**MAINE MEDICAL CENTER
MEDICAL OFFICE BUILDING
PARKING STRUCTURE AND
OVERHEAD CONNECTOR**

**883 - 887 CONGRESS STREET
PORTLAND, MAINE**

**Re: Response to Jaimey Caron's December 11, 1997 Memorandum
Maine Medical Center Office Building
Congress Street**

**RE: Maine Medical Center
Medical Office Building**

METAL HALIDE
FIXTURE @
STAIRS ONLY

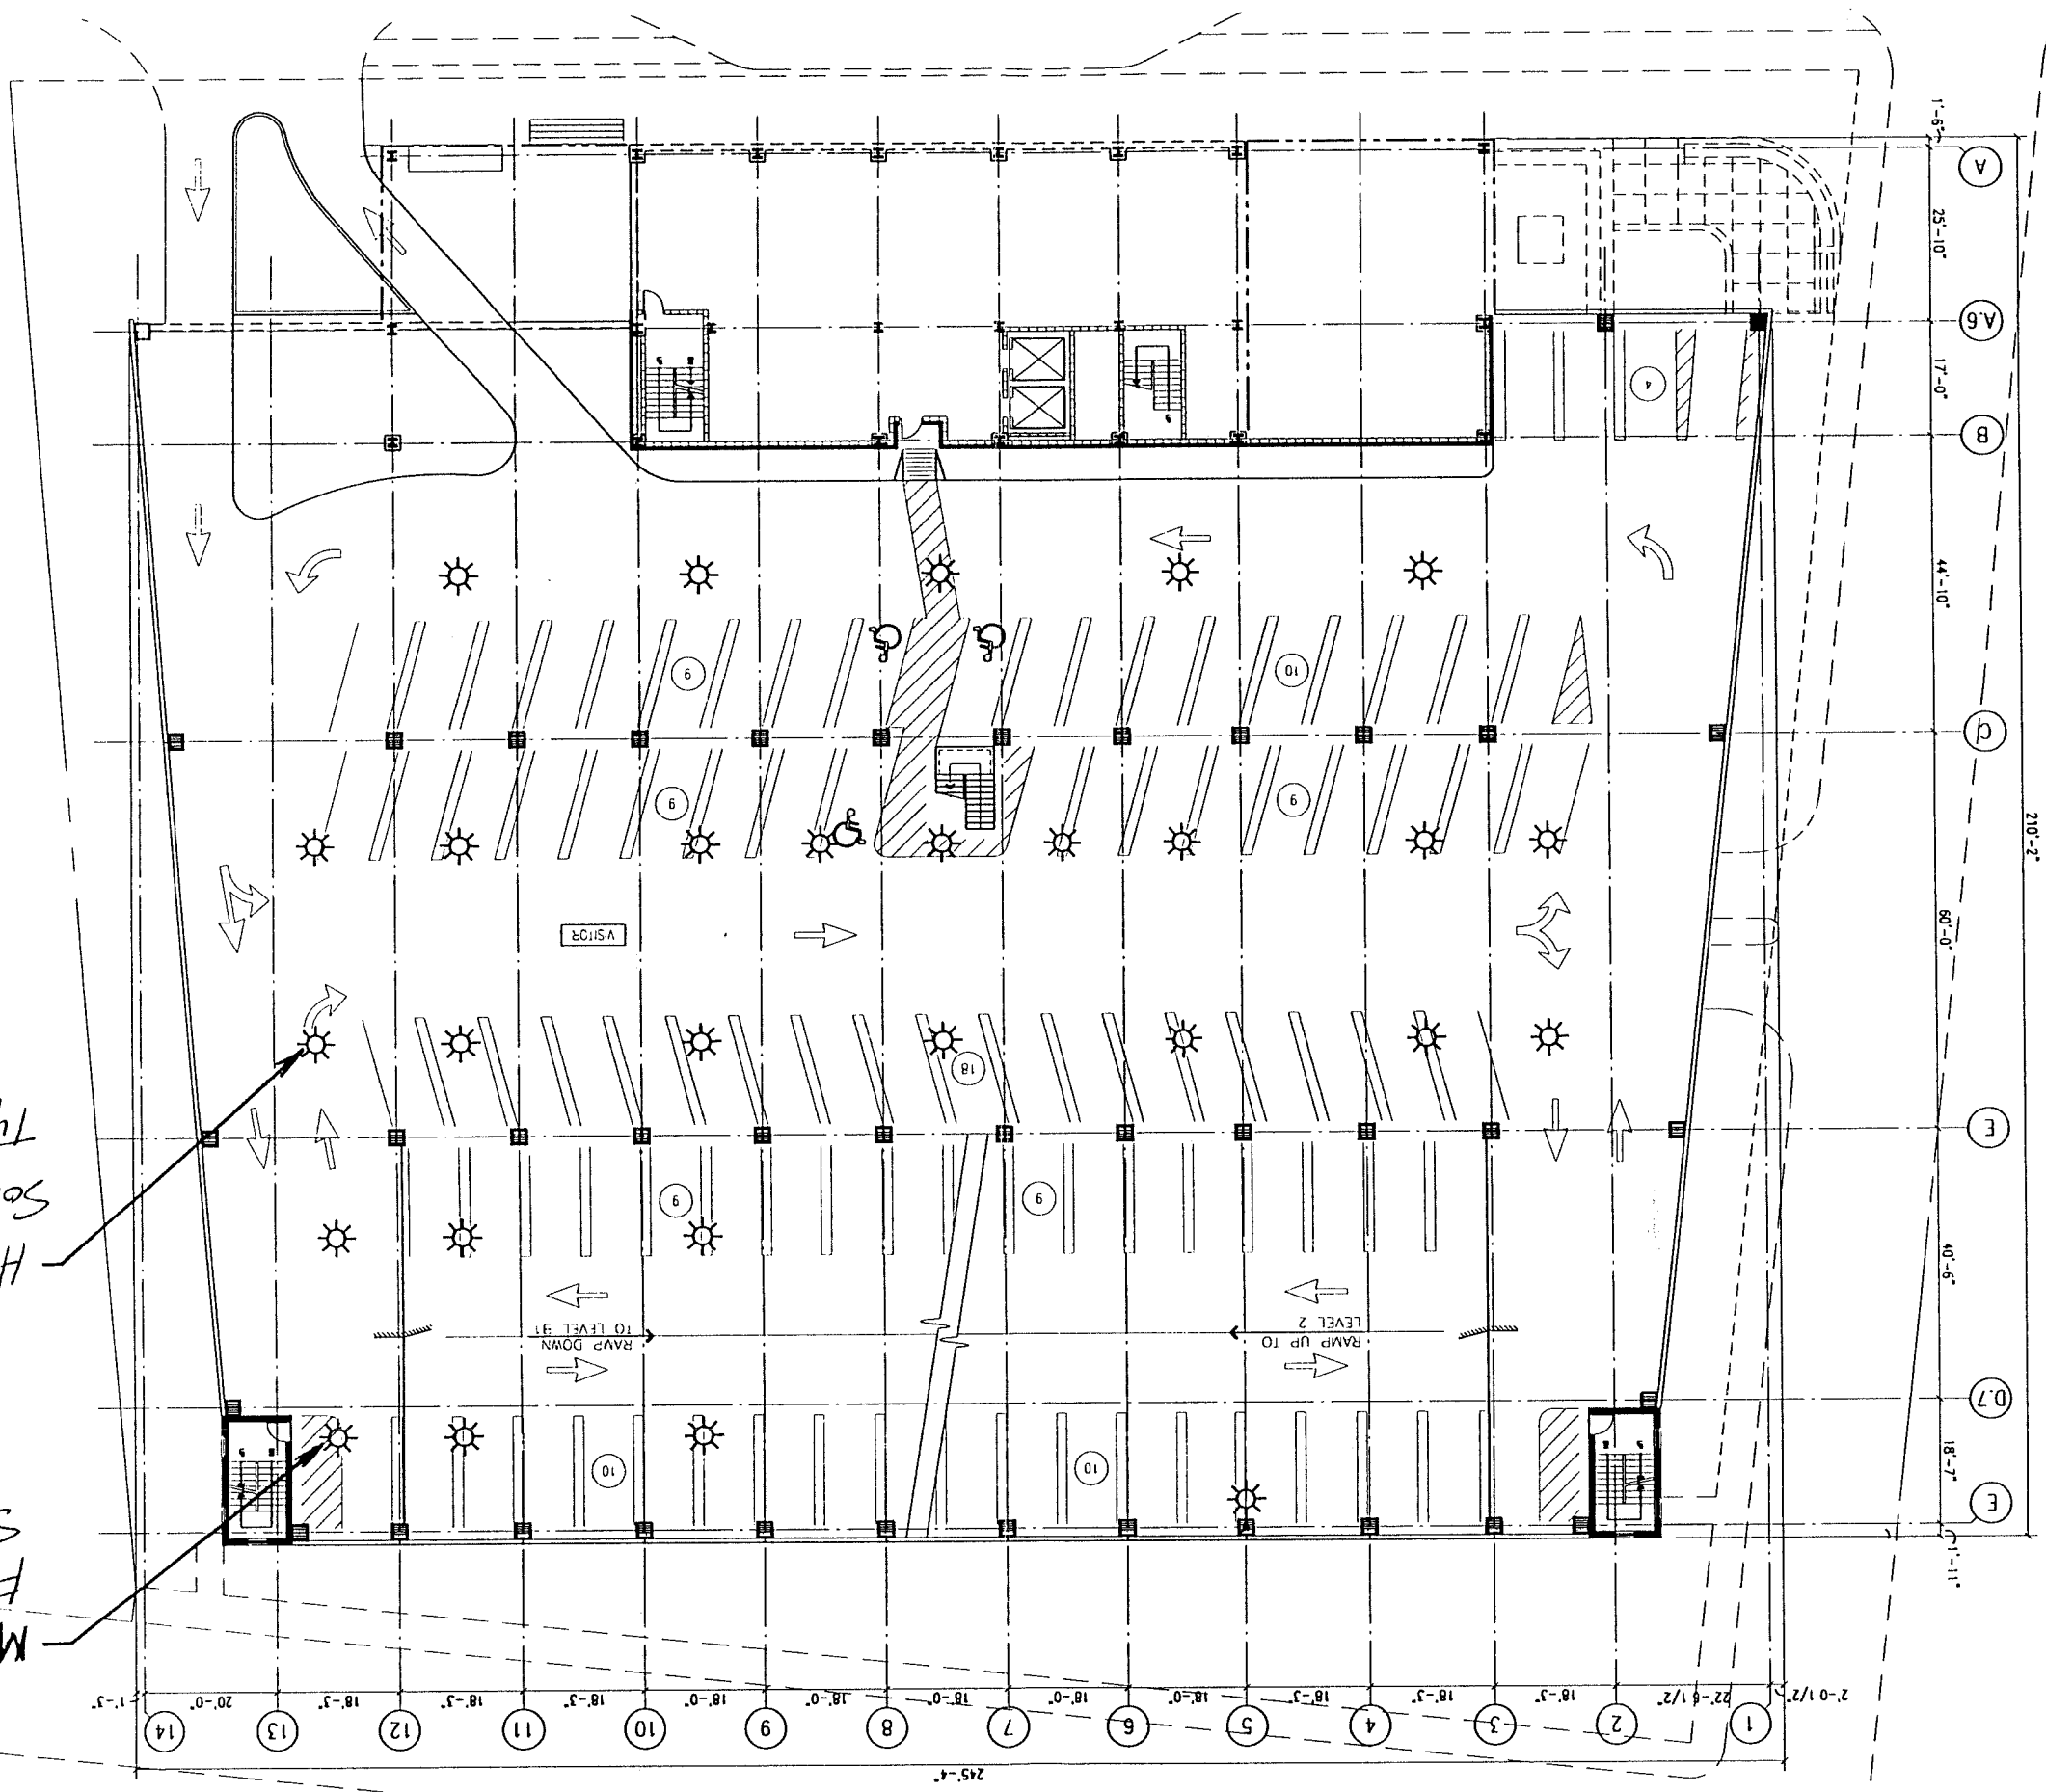
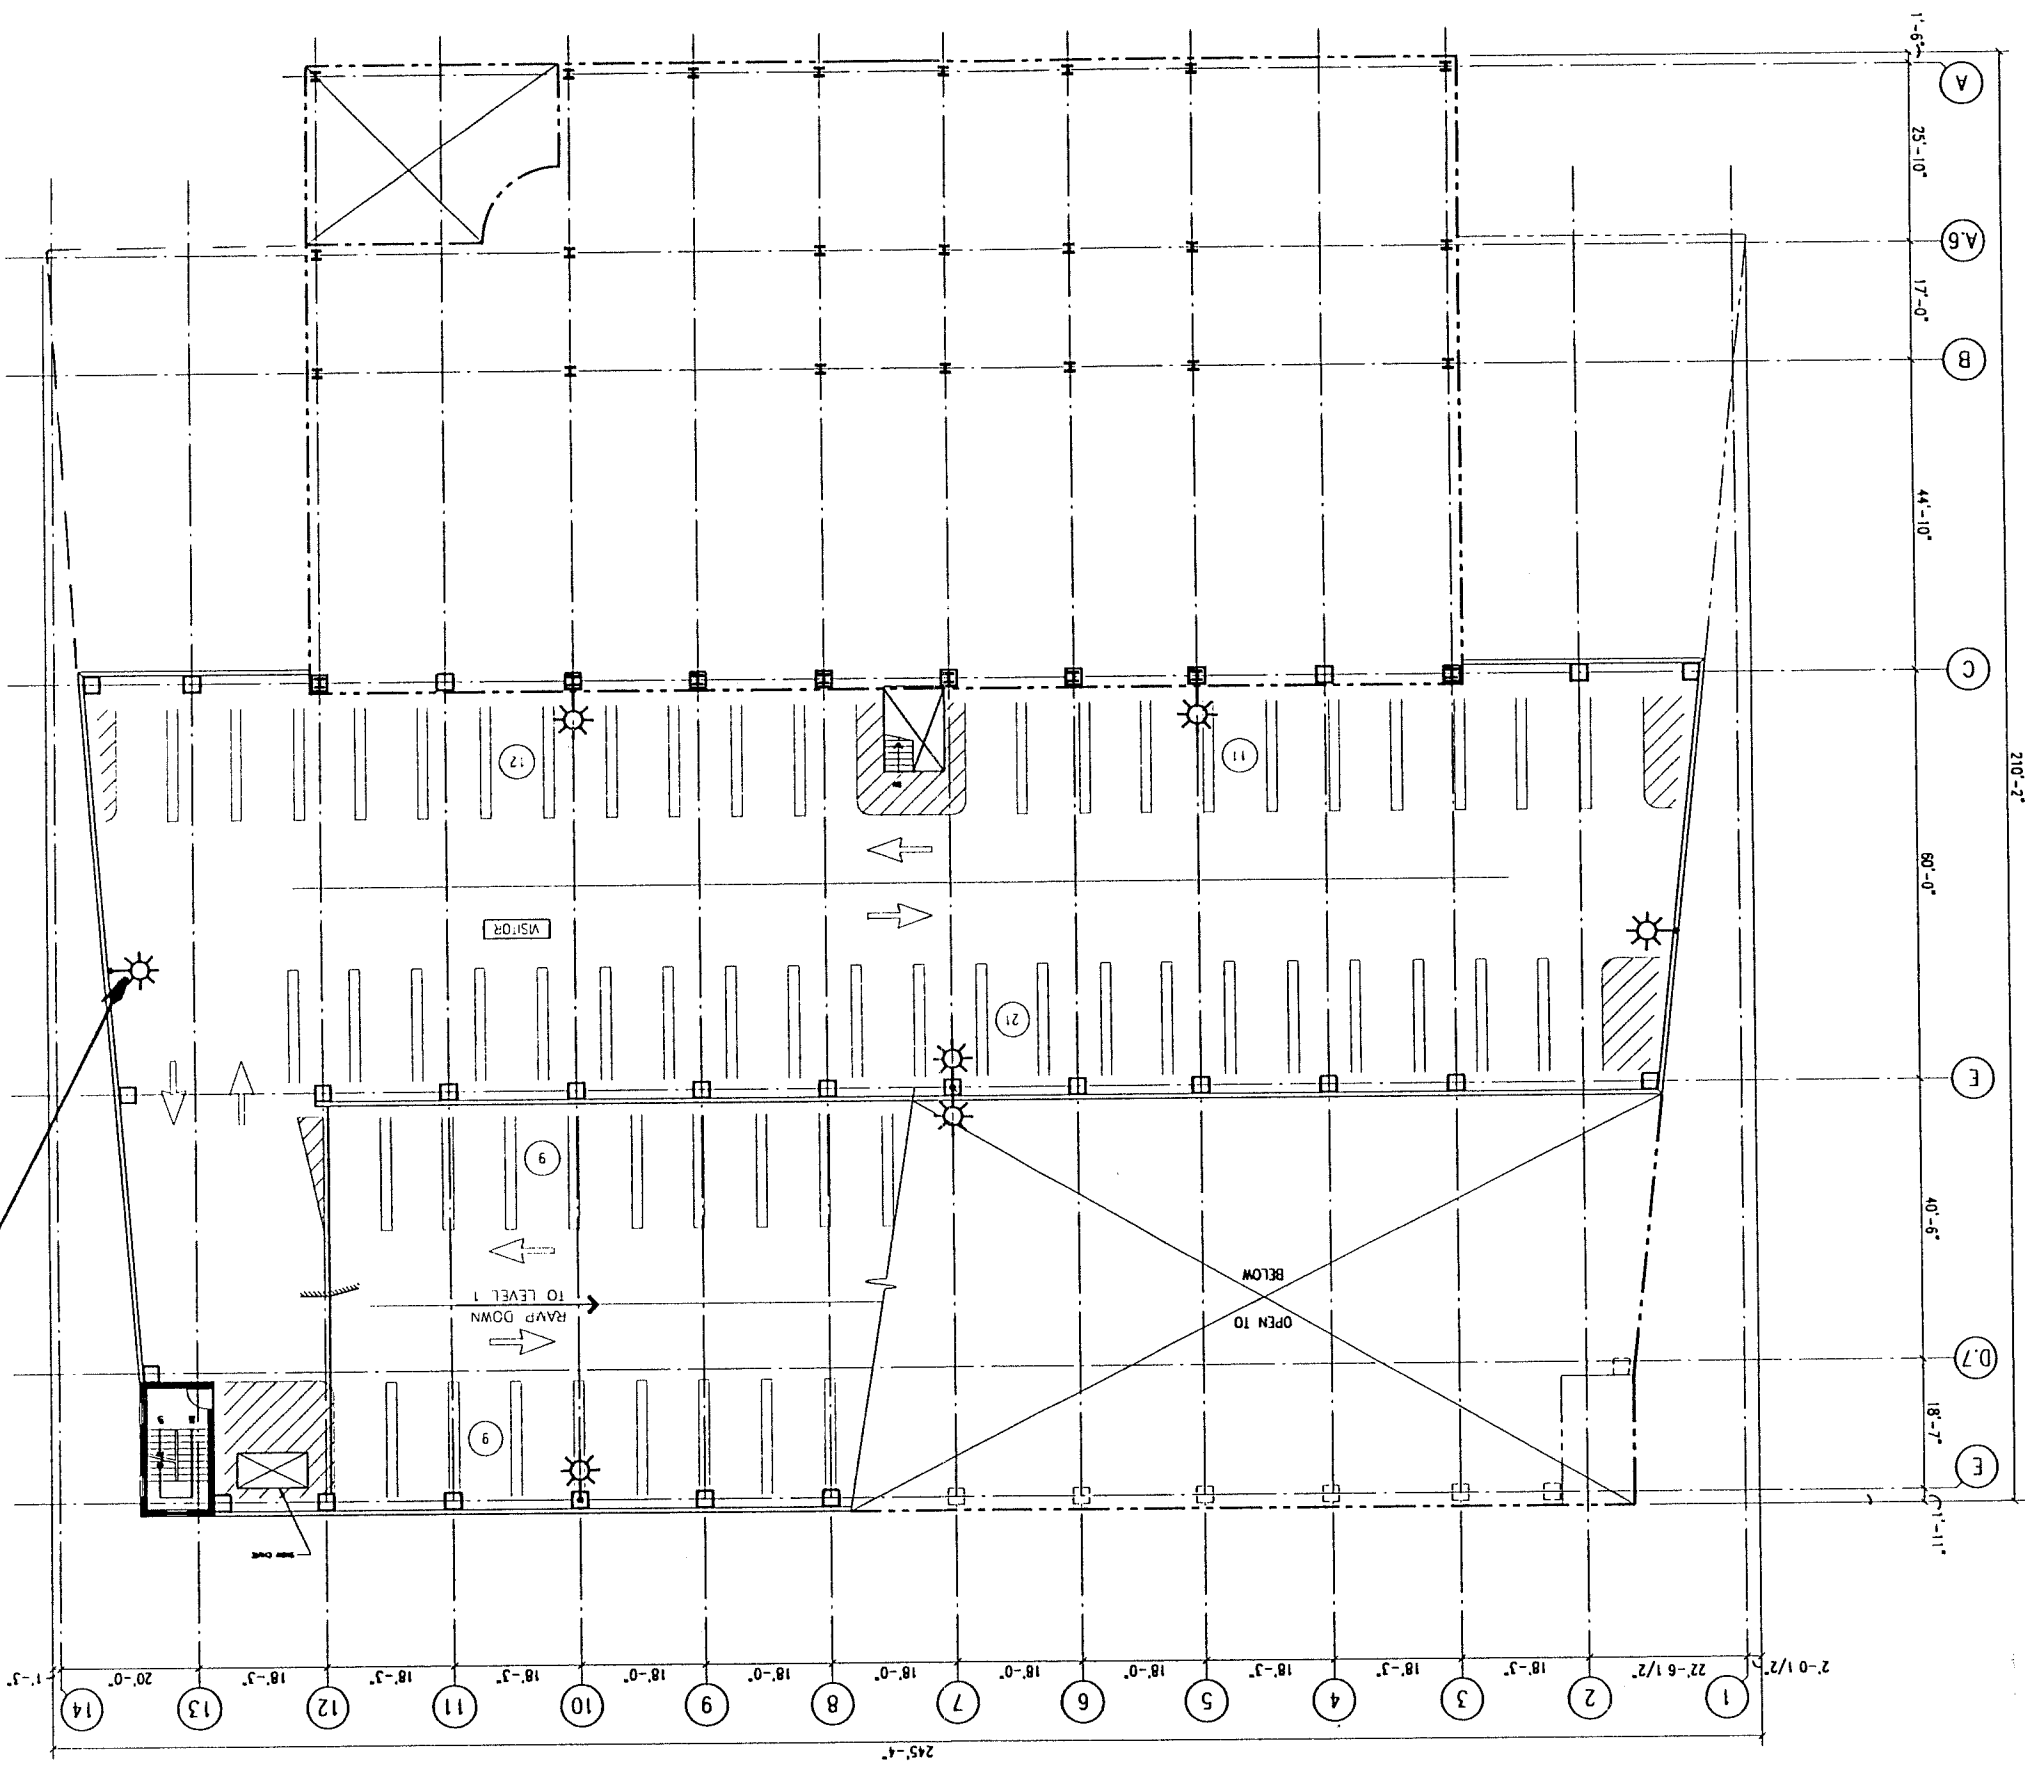
In the event that light poles on the roof of the garage are included in the final submission, I would like a condition of approval crafted that would restrict the height and location so as to be inconspicuous to the surrounding neighborhood on three sides.

MMC continues to work with the staff on the lighting issue.

ELIMINATE 2 PARKING SPACES

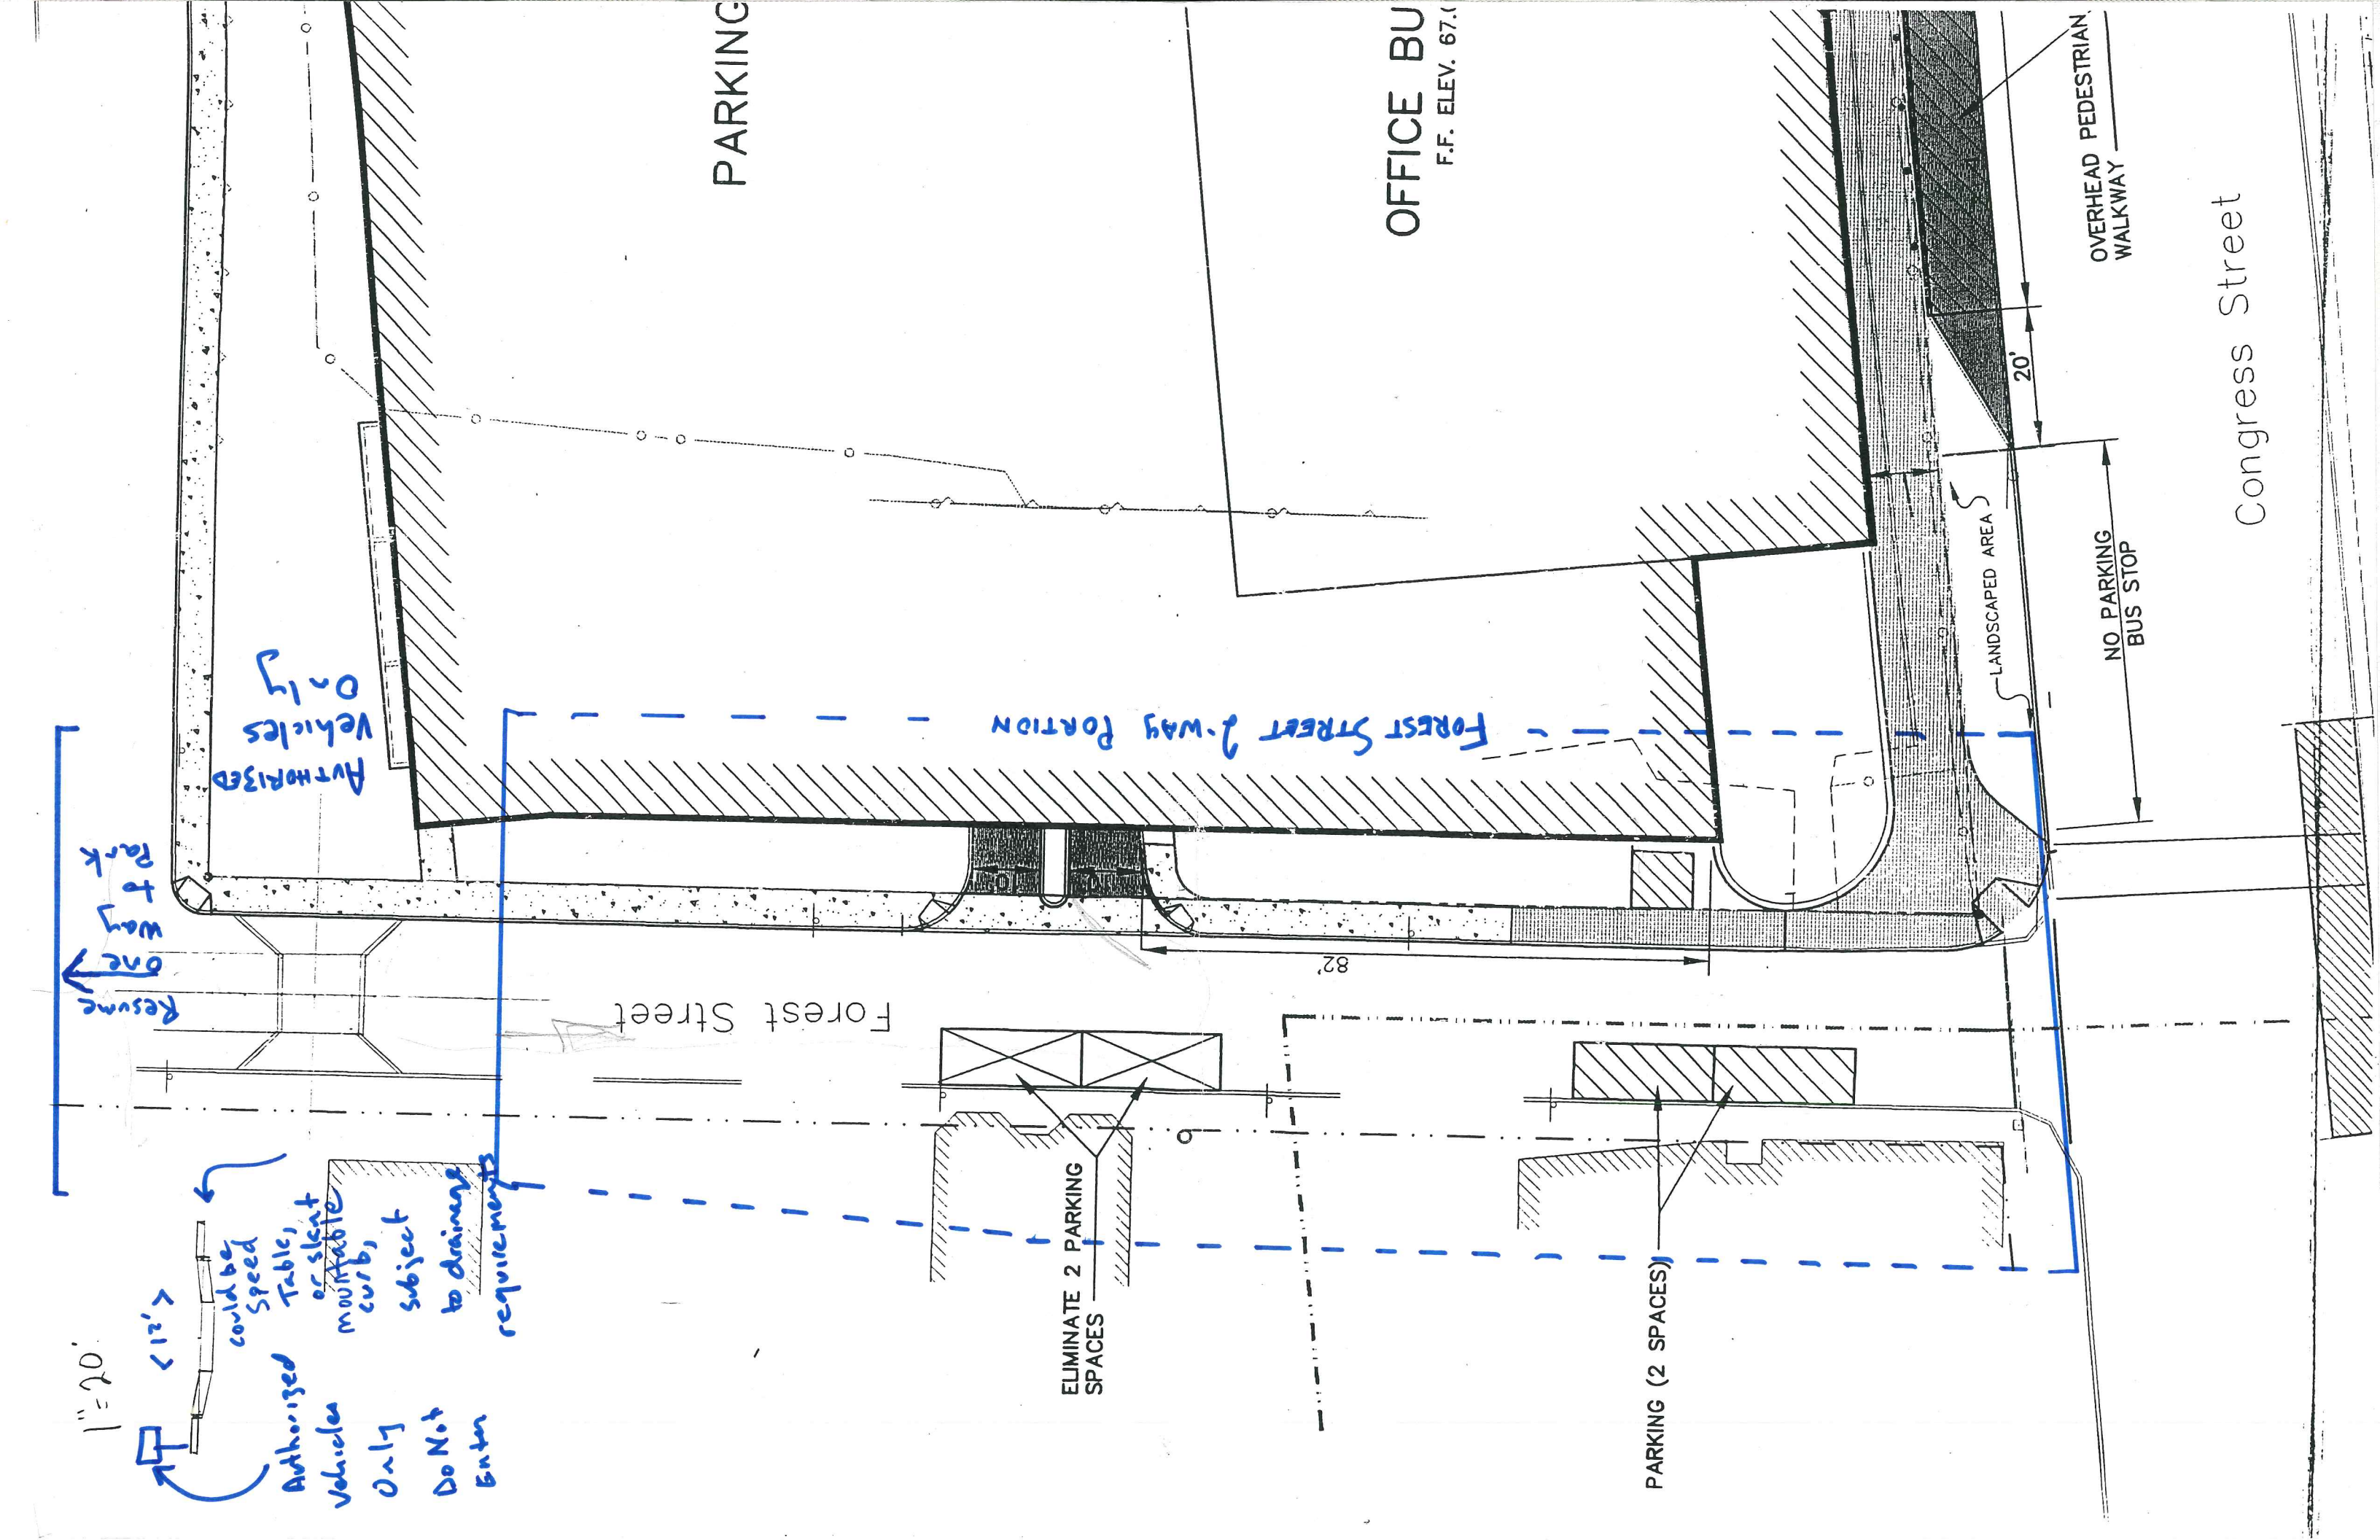
At the workshop, the applicant indicated that parking would need to be removed from Forest Street in the area around the access drive to the garage. Because of the narrow street width, the applicant's traffic engineer stated that Forest Street may be blocked at times if these spaces are not eliminated, particularly in the winter. It is the applicant's responsibility to mitigate the impacts of their development. Since removing these parking spaces requires City Council approval, a condition of approval should be included that, in the event the City Council does not grant the request, the applicant shall submit a revised site plan for the Planning Board's review. An alternative approach would be to provide a turning lane adjacent to the garage on MMC land.

MMC is working with Mr. Bray and Mr. Ash to prepare a request to remove 26 spaces along Congress Street. The city is proposing to remove two spaces directly across from the proposed Forest Street driveway and MMC is working with Mr. Bray on that issue.
